WEST SUSSEX COUNTY COUNCIL CONSULTATION

TO:	Arun District Council Mrs A Gardner
FROM:	Debbie Farrell County Highways - WSCC
DATE:	20 March 2018
SUBJECT:	CM/5/18/PD Prior approval for the proposed change of use of agricultural building to B8 Storage or Distribution. Church Farm, Church Lane, Climping, BN17 5RB
DATE OF SITE VISIT:	
RECOMMENDATION:	☒ Advice ☐ Objection ☐ Modification ☐ No Objection ☐ More Information ☐ Refusal
S106 CONTRIBUTION TOTAL:

Location and Access plan

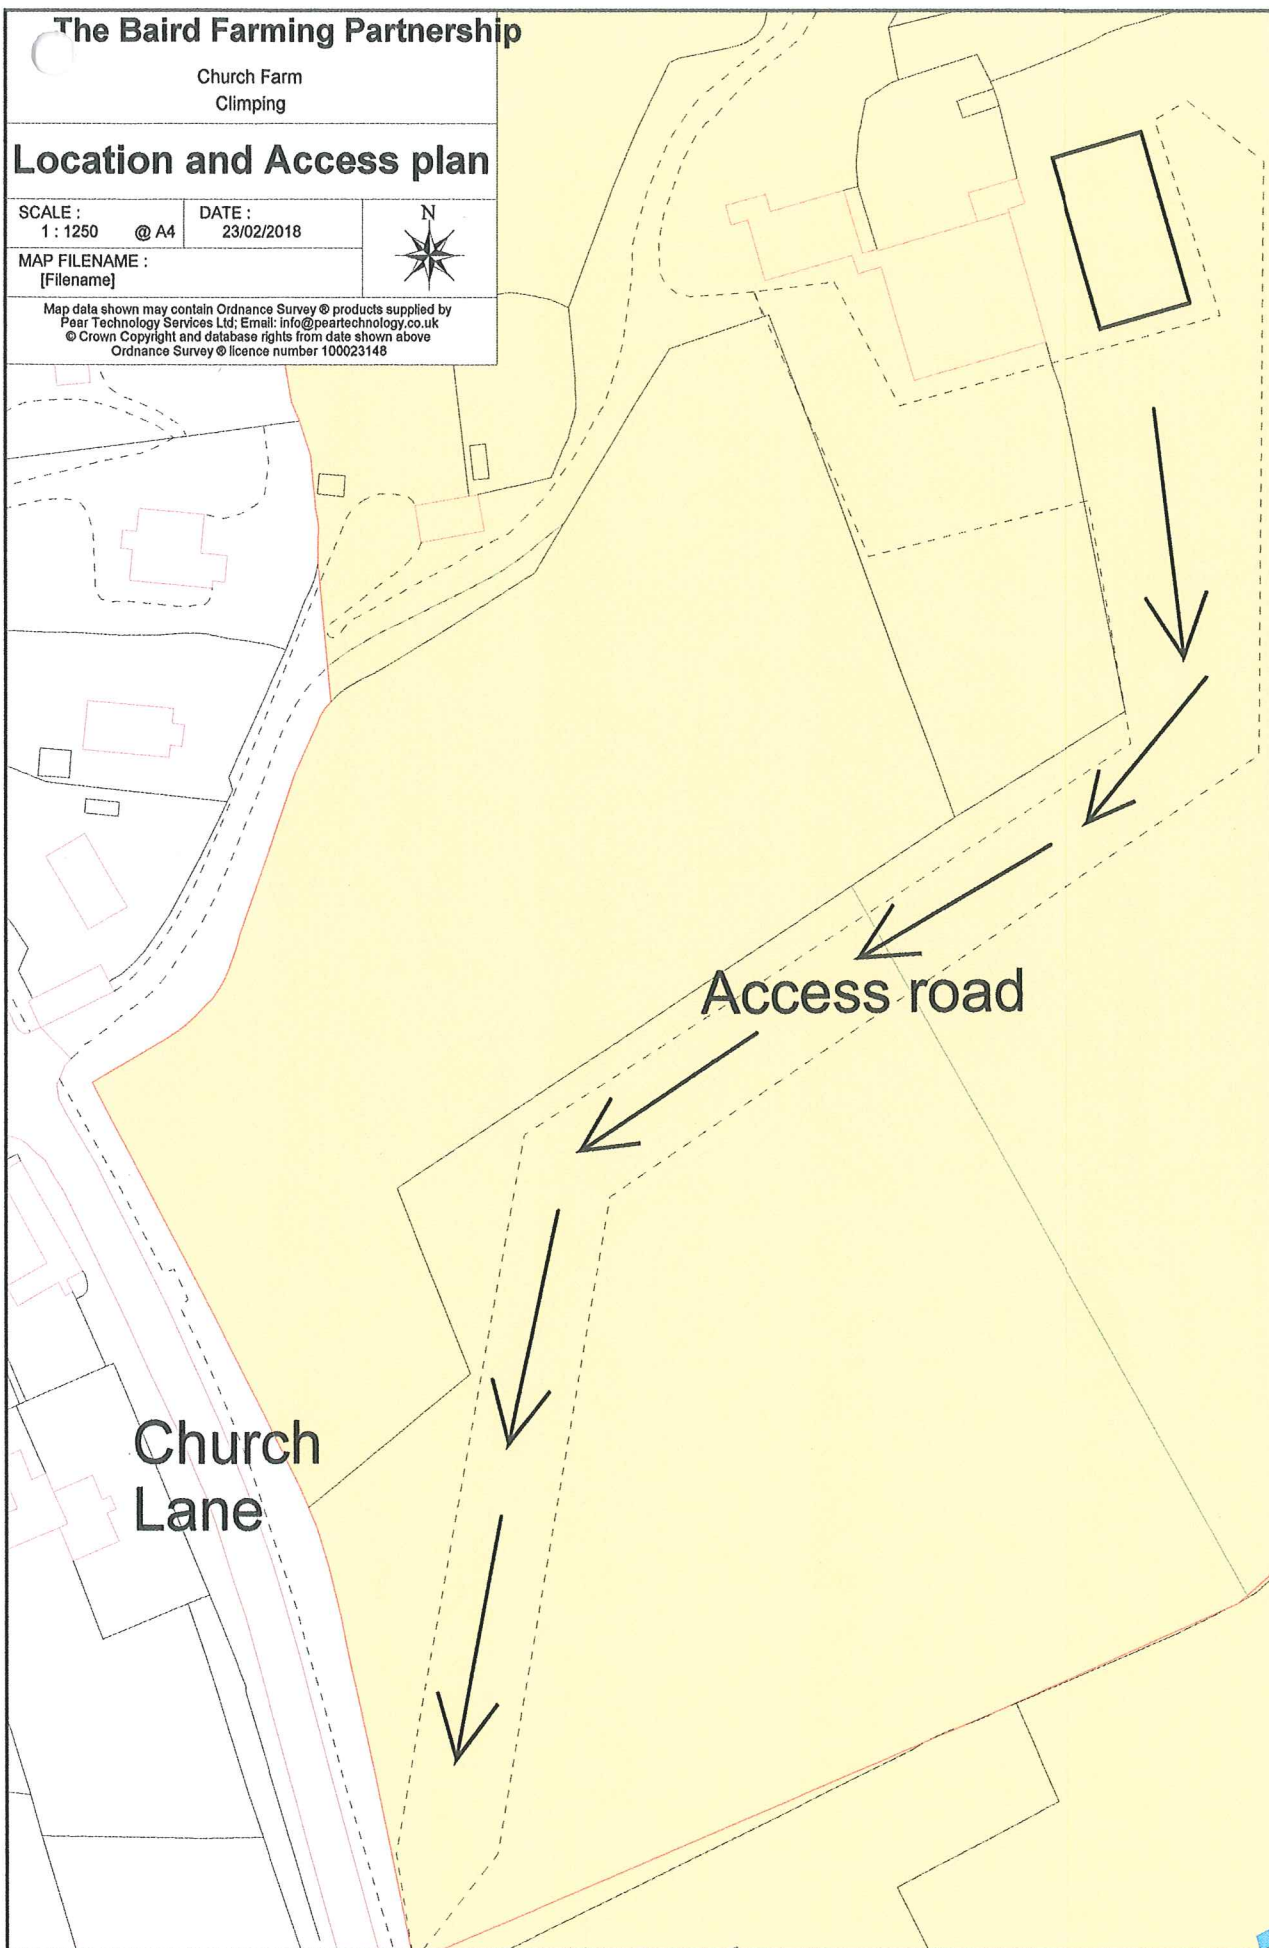
The existing access has clearly been designed for farm/large vehicle and is of sufficient width for a large vehicle to access from the south. However, given the angle of the access, larger vehicles may have difficulties accessing and exiting the site when approaching from the north. This issue may not have been problematic for low levels of traffic, for articulated farm vehicles or for vehicles approaching from the south, however it is a concern due to possible intensification in use in relation to the proposed change of use. **A plan showing the swept path for a large HGV entering and exiting the site access is required.**

Visibility to the south is good exceeding 120m however visibility to the north is somewhat restricted by overgrown hedging. It would appear that a visibility splay has been provided in the past, however a commitment from the applicant to maintain the splay is required. 2.4m x 120m is required in both directions.

No parking spaces have been shown on the plans. In accordance with WSCC parking standards a total of 15 car parking and 2 lorry parking spaces are required for 500sqm of B8 Storage and Distribution use.
